**To:** Mr. Brad Sutton, Code Enforcement Officer, Harnett County Inspections  
**From:** Ron Ward Webb, Architect  
**Date:** March 10, 2025  
**Re:** Mount Pisgah Harnett OFWB Church

Thank you for your most recent Plan Review comments. Without taking away from Mr. Tommy McLeod's comments, I will offer the following additional comments:

cc: R. Hinton, G. Surles, G. Blue, T. McLeod, file  
code: PR Response #2

HVAC TITLE SHEET

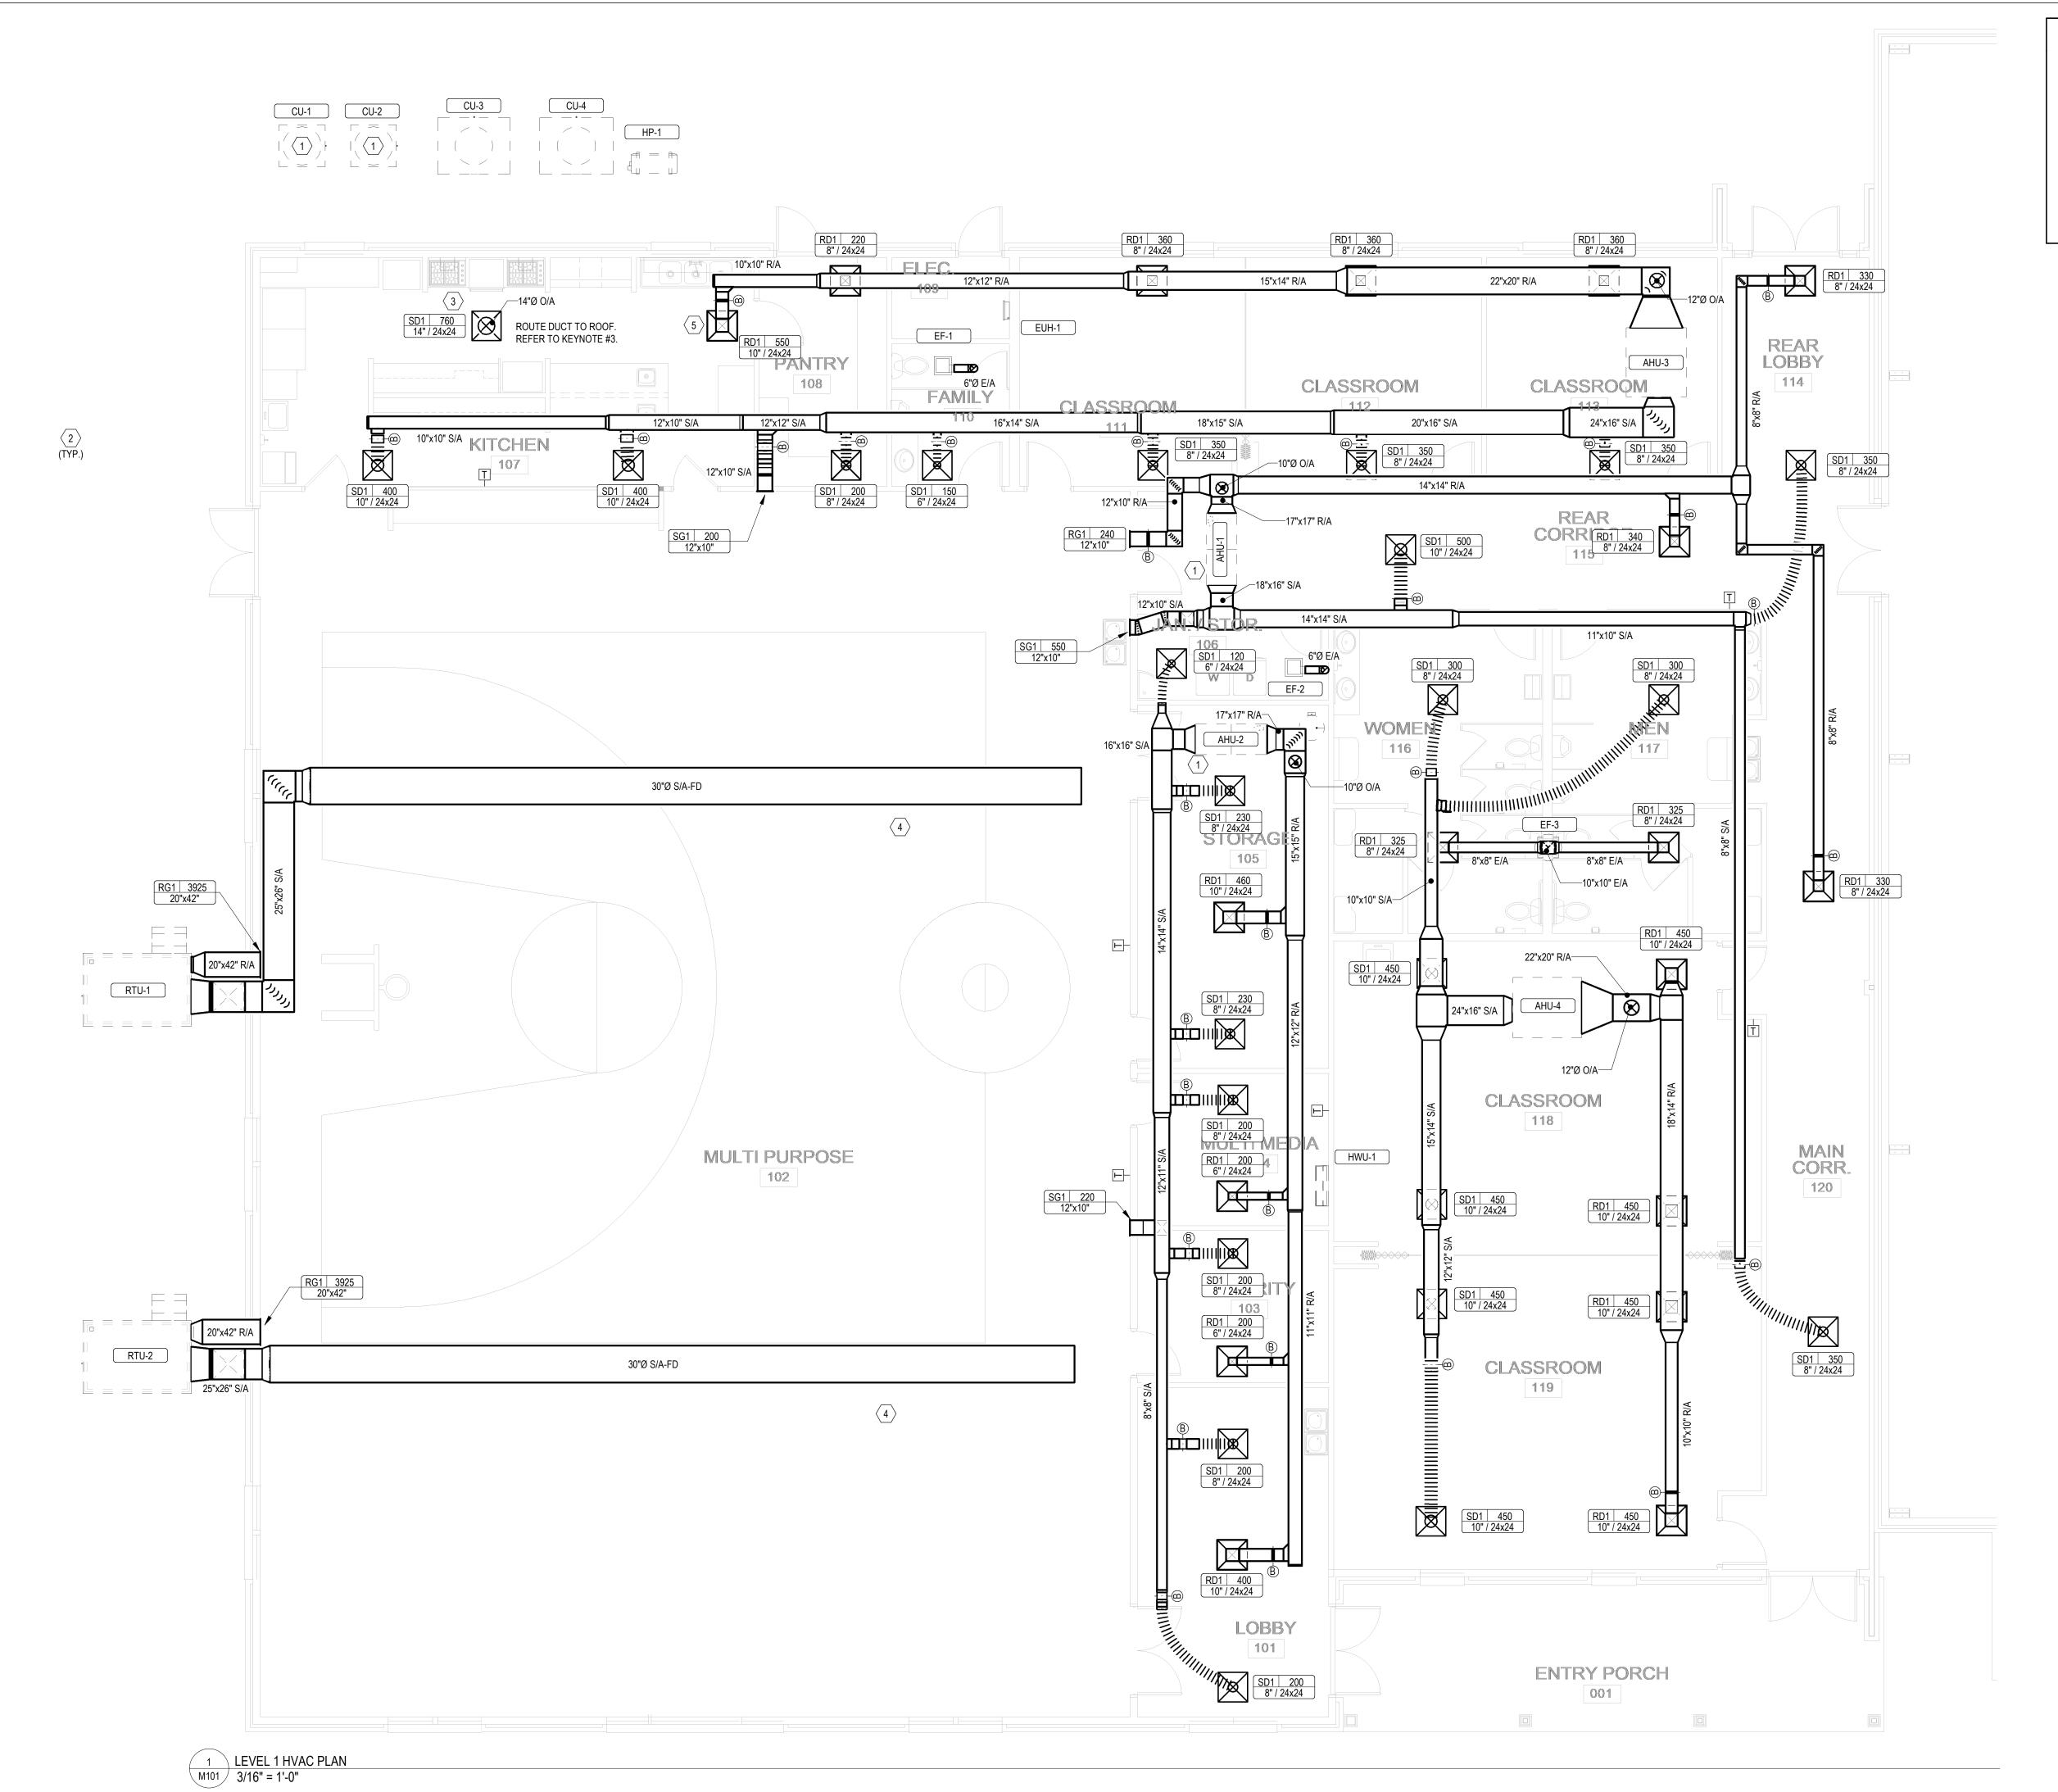
Your Item No. 5: Drawing M000, Note P states to provide duct smoke detectors. Also Drawing M401, Detail #3 shows the duct mounted Smoke Detectors.
